Reference: Application: A/18/8/PL Location: Land Rear of 1 to 6 The Cottrells, Angmering

We write in objection to the above planning application on the following grounds:

Block Plan

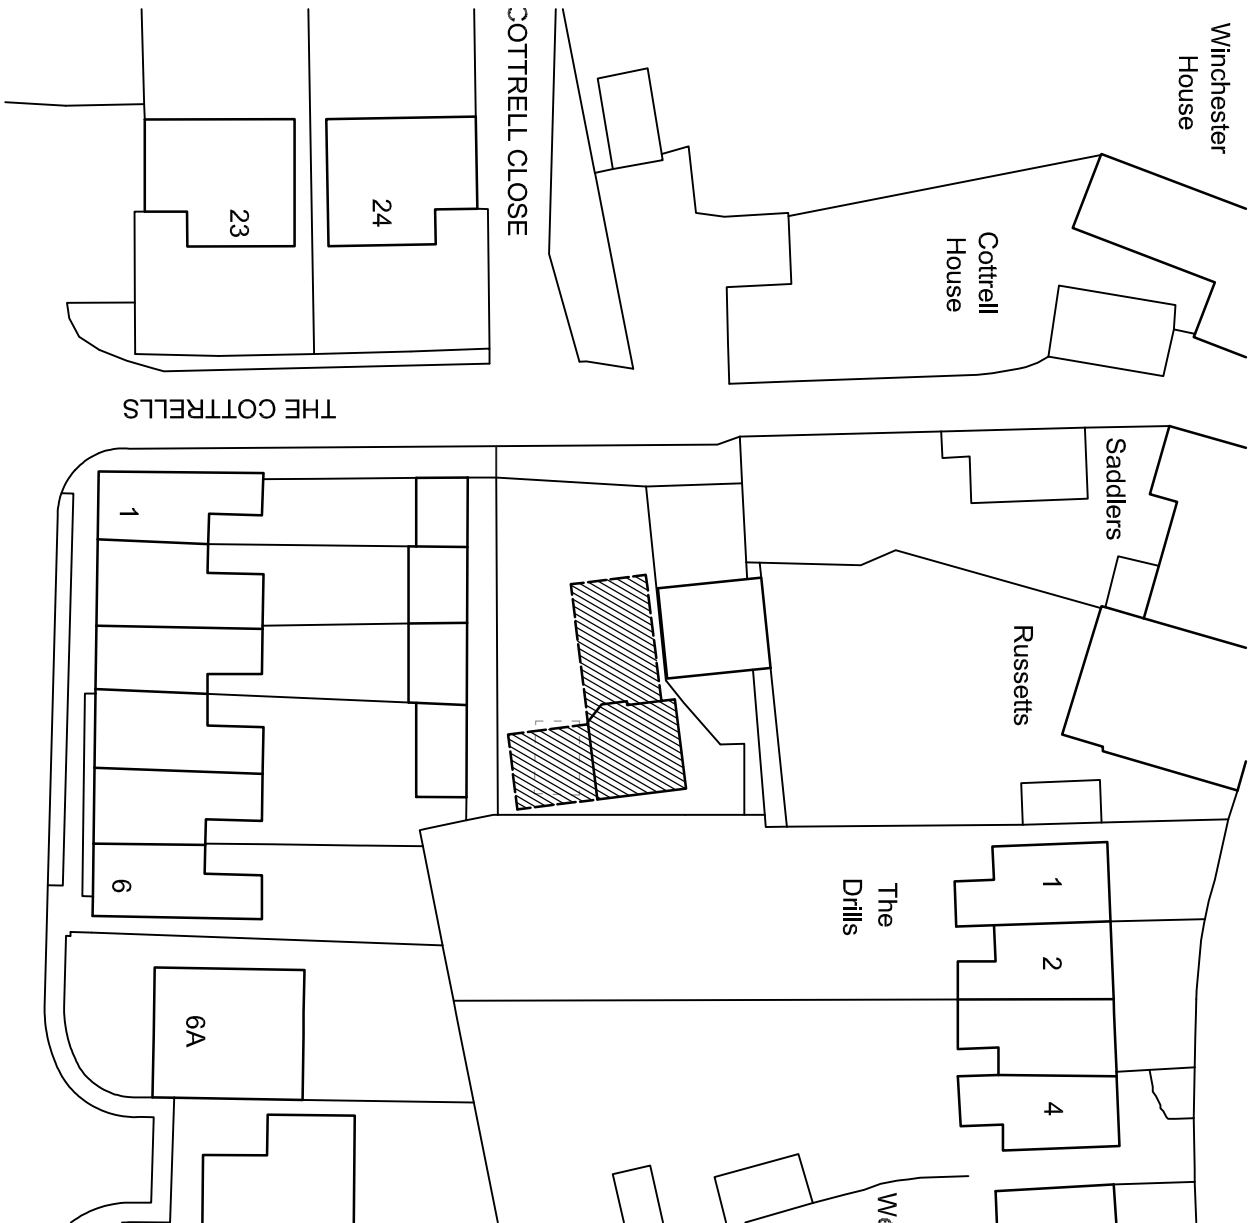
5. The low wall on the south boundary adjacent to the car parking space marked Public 7 impedes on a man hole cover belonging to another property. Is this compliant with Building Regulations?

Ground Floor Plan @ 1:100

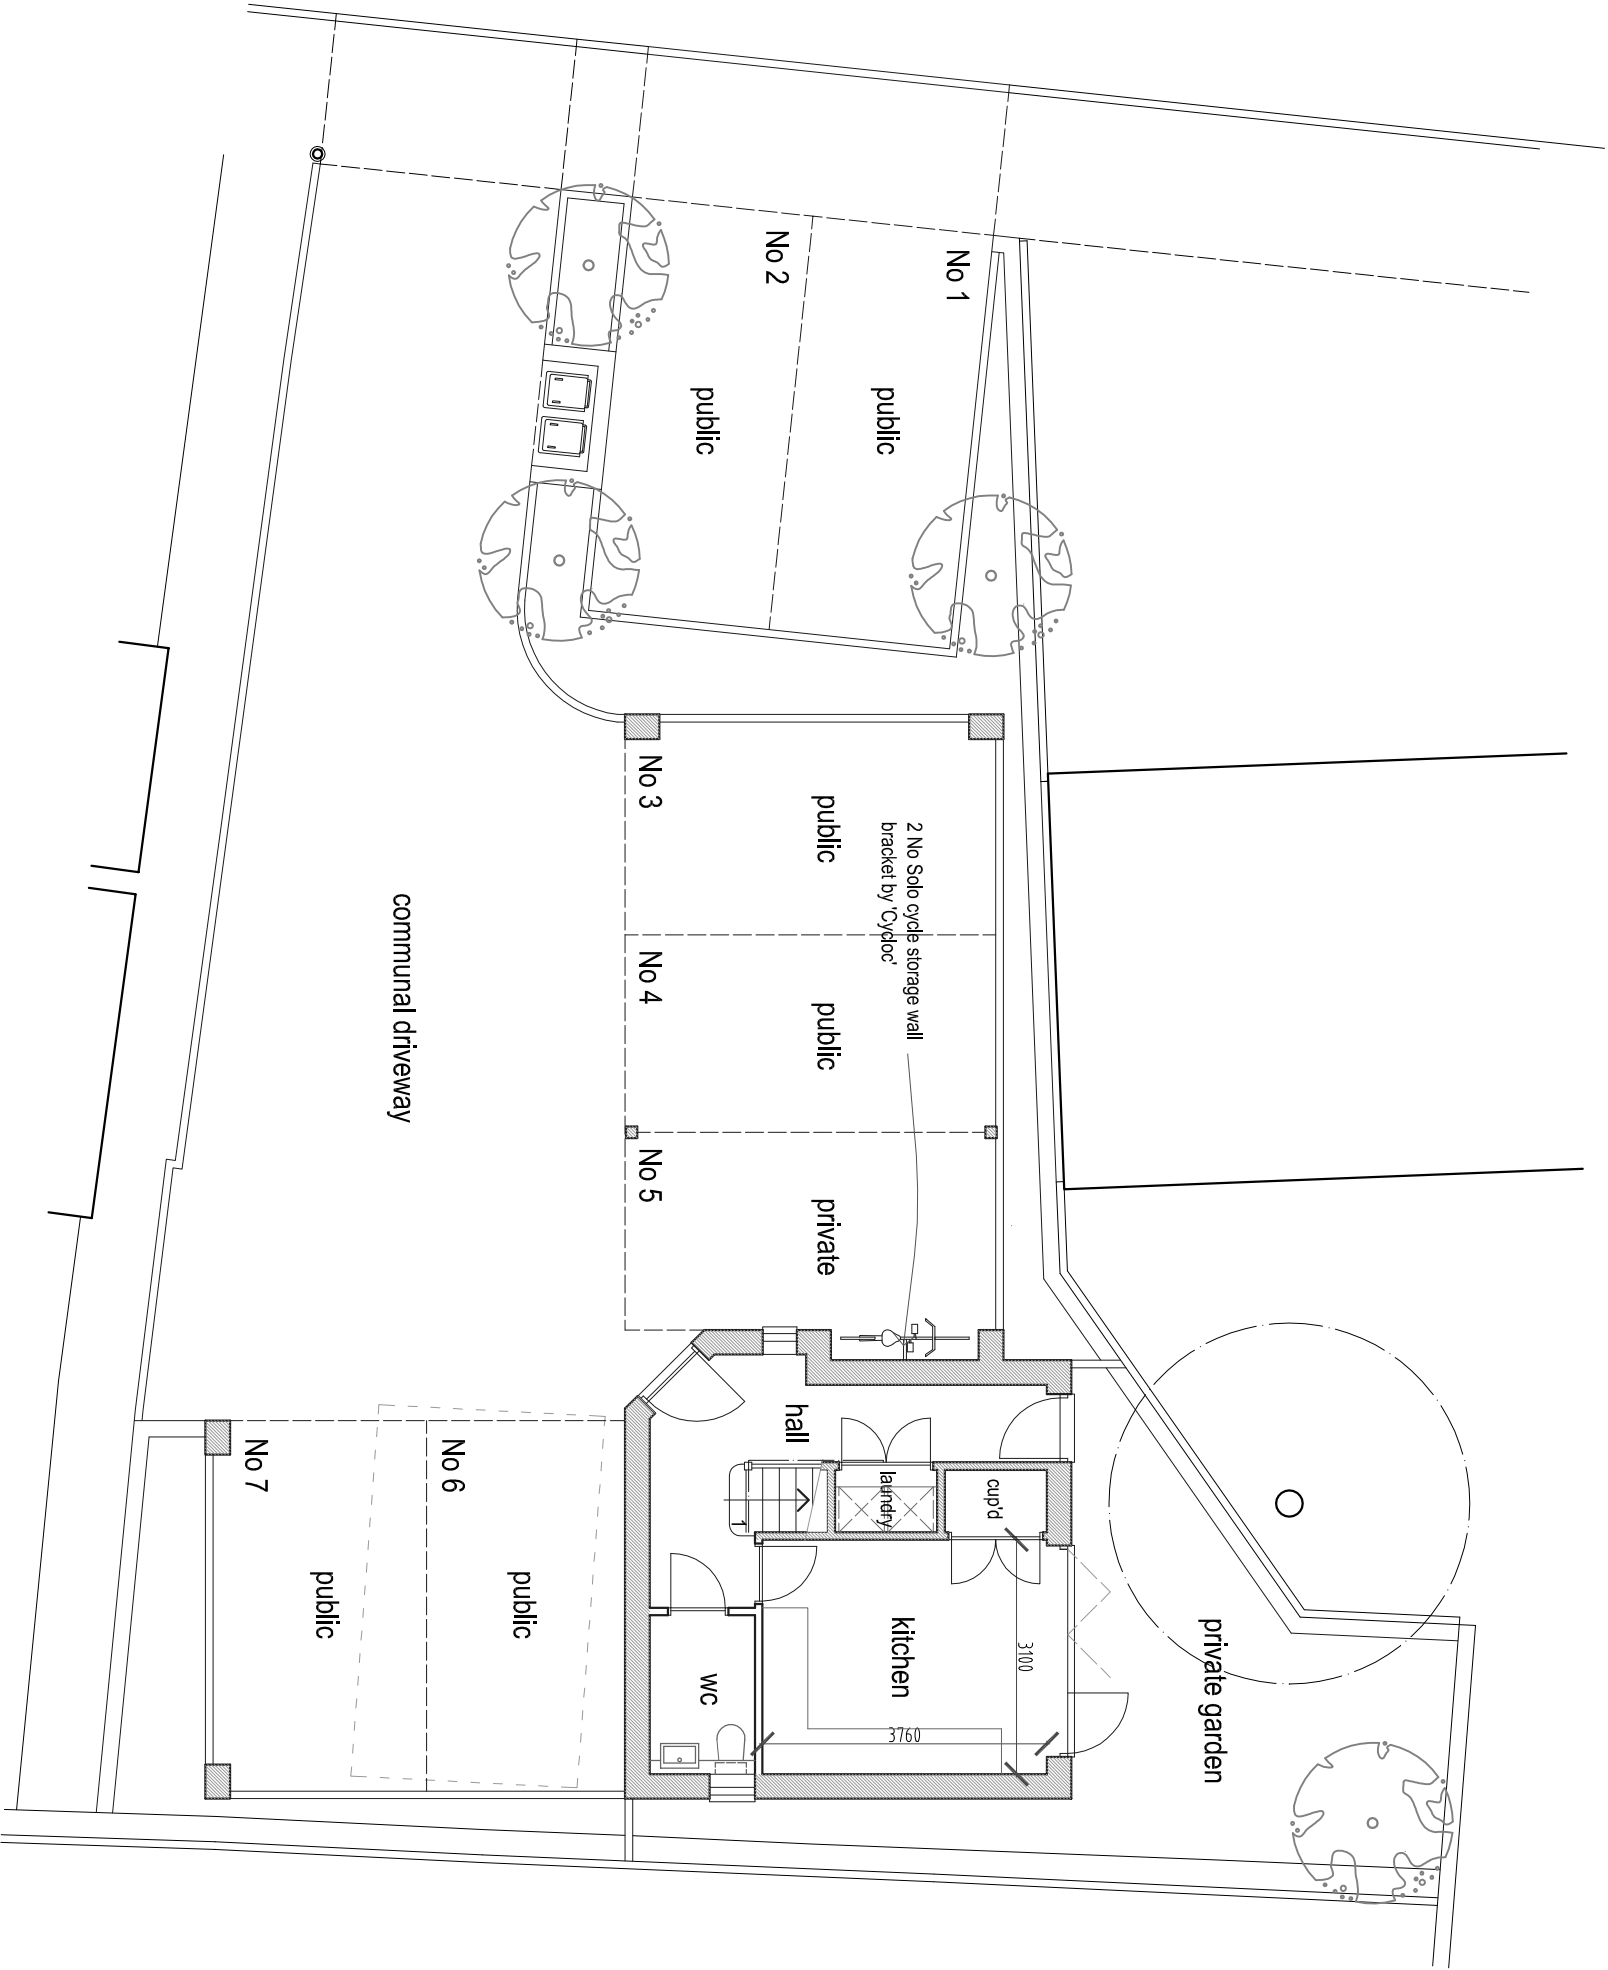
3. The proposed plans alter the internal layout of the building. we are concerned that this could make it possible to convert the building into 3 bed roomed accommodation at a future date. This would in turn increase the likelihood of more cars associated with the property and further stress the availability of parking in the already congested neighbourhood. Can we be protected from this happening by making any internal re- configuration subject to planning consent?

Roof Plan @ 1:100

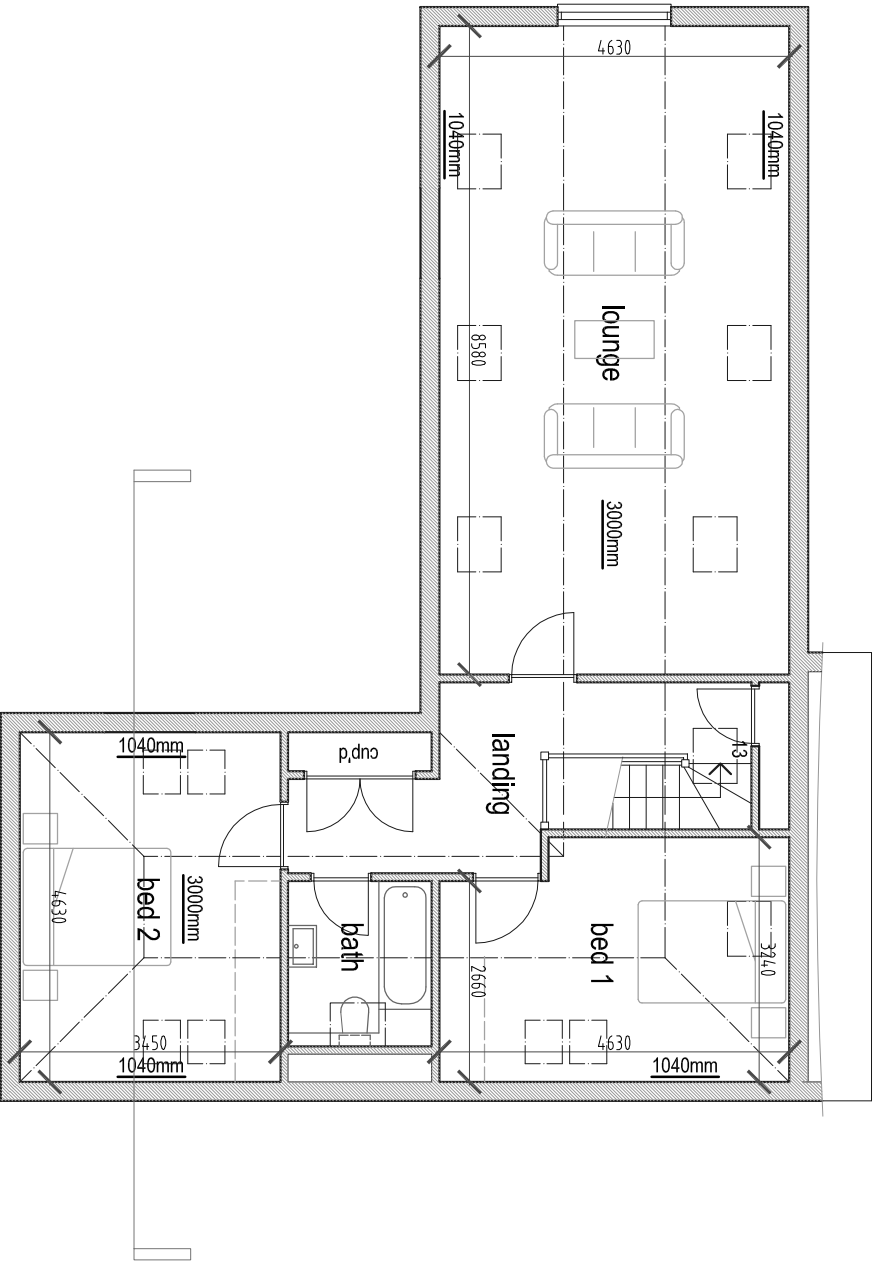
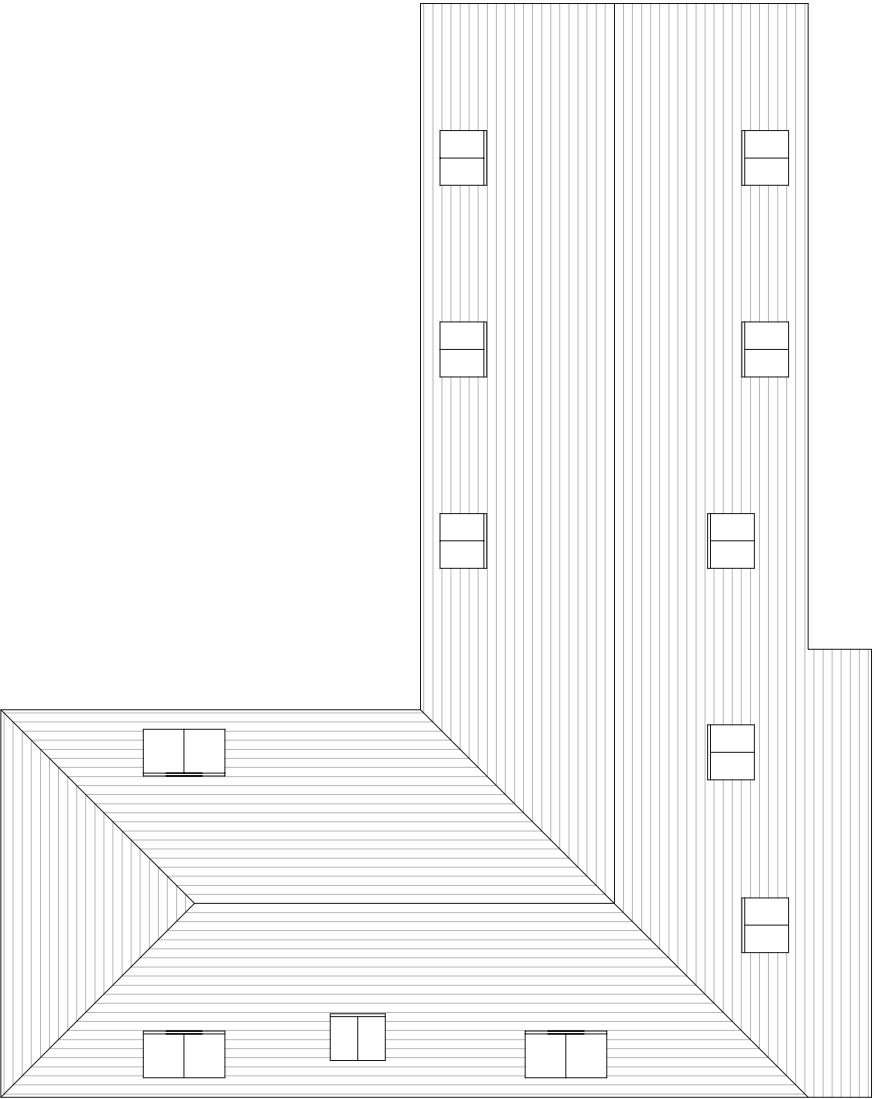
1. The submitted plans and the current building show a different roof line to that on the approved plans. We object to this as the increase in the size of the roof and the dwelling and does not blend into the local area.

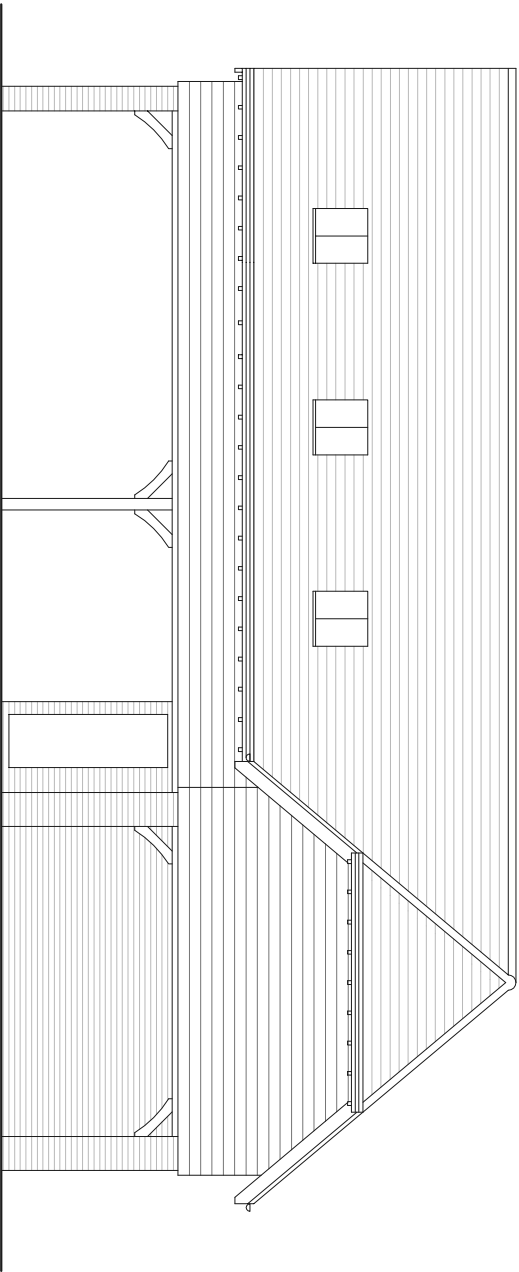
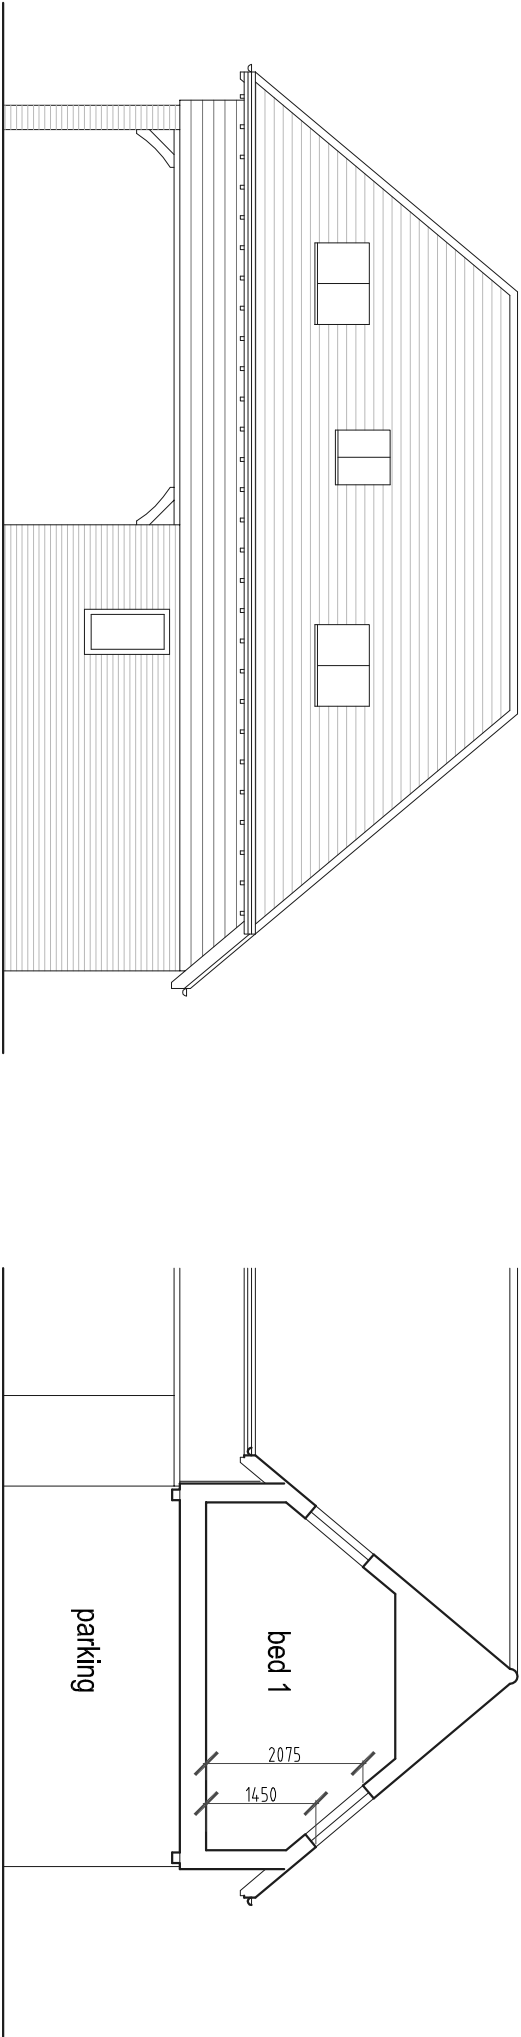
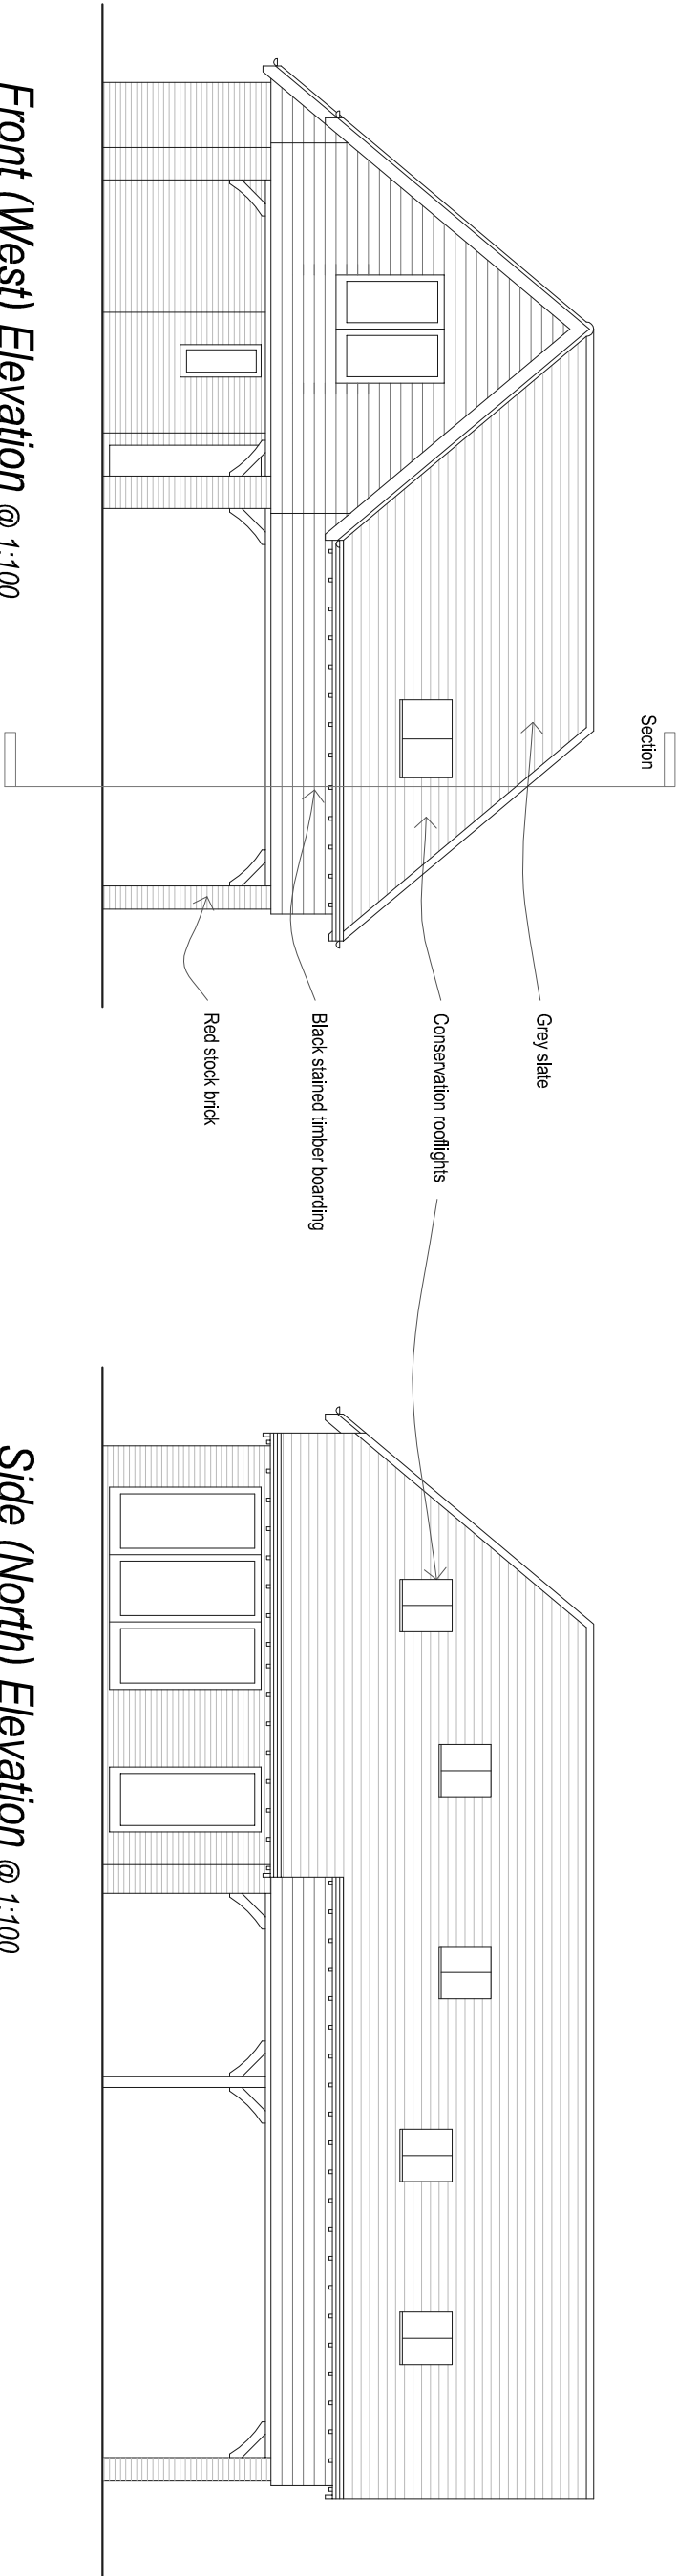
2. The windows shown on the application and currently installed are lower than those on the approved plans which not only compromises the privacy of adjoining properties, it gives them a more dominant appearance than was approved.

4. The new plans show brick and not timber uprights. We ask for the conservation officer to be consulted if this is appropriate in the conservation area.
